Town & Country Planning Act 1990 (as amended)
Town and Country Planning (Development Management Procedure) (England) Order 2015
Application for approval of details reserved by condition imposed under planning permission
WA/27/15/PL (Appeal reference APP/C3810/W/15/3132744) relating to condition No. 4 (Schedule of
materials), 5 (Contamination risks) & 8 (Surface water drainage scheme)
Deans Yard Orchard Way,Fontwell,

Arun District Council have decided to **REFUSE details reserved by condition for the following reasons:**

Condition no.8 Surface Water Drainage

Job Title	DEANS YARD FOOTWAY	Job No.	HAL 057	Sht. No.	S1
Element	SOAKAWAYS	Prepared	DR	Date	Nov 17
		Checked		Date

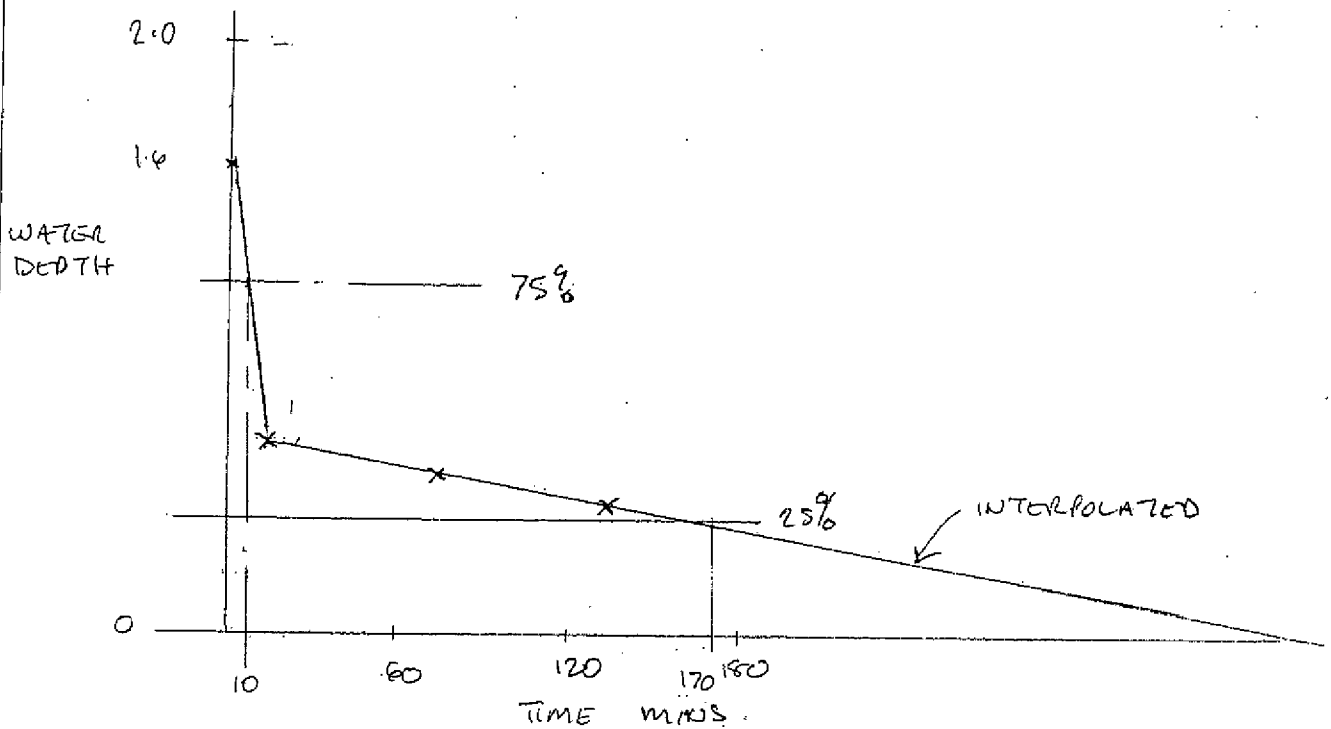
1. There is no evidence of winter groundwater monitoring. This should have been carried out at an agreed time. Full details of the percolation testing are also required (ie.dates/locations/readings, etc). These items are critical to the design.

2. The scanned copy of the layout drawing is very poor, so levels are not readable. Please supply a better copy.
3. Storage calculations $\hat{\Delta}$ will also need to be provided for the permeable pavement and all calculations need to include 30% allowance for climate change.

Surface Water Drainage Plan

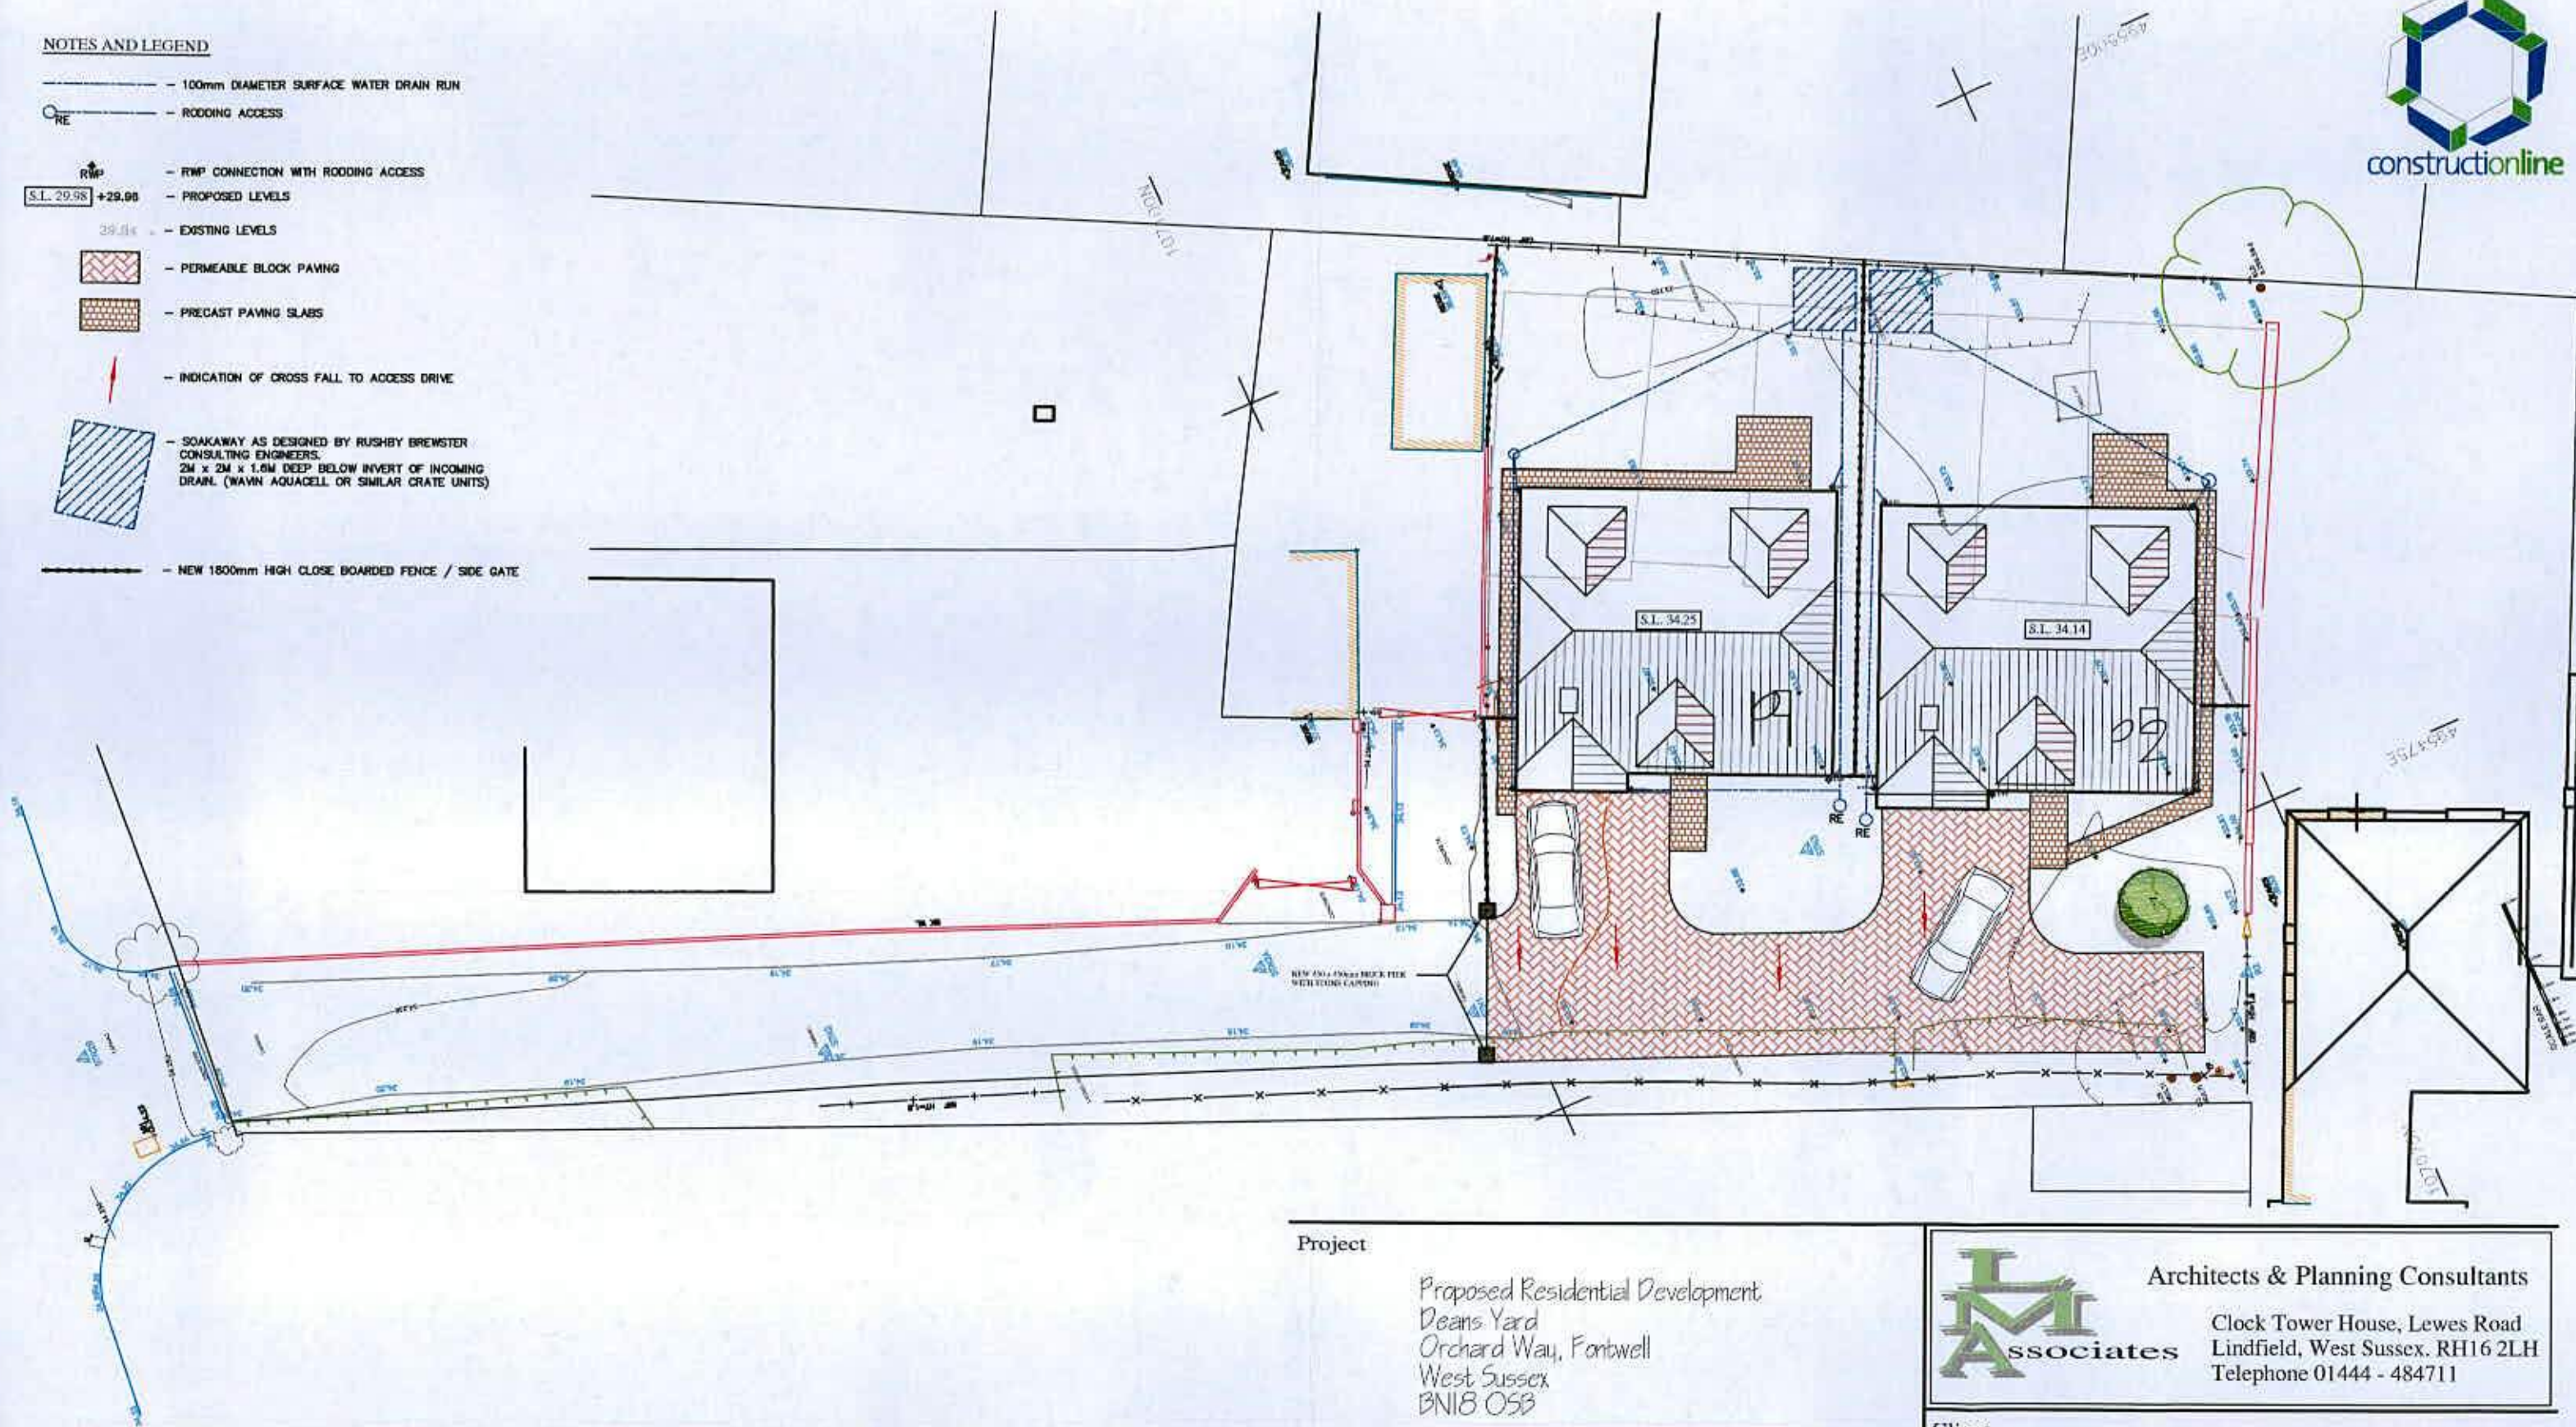
4. Full construction details will be required for the permeable pavement and crate soakaways.
5. Silt trap manholes to be provided upstream of the crate soakaways. Specify on plan and provide construction details.

6. The two soakaways are too close together and this will affect their performance. Please adjust.
7. Pipe gradients/invert levels/soakaway base levels/cover levels/finished surface levels will all need to be provided.

8. Please confirm if the existing driveway is to be reconstructed.
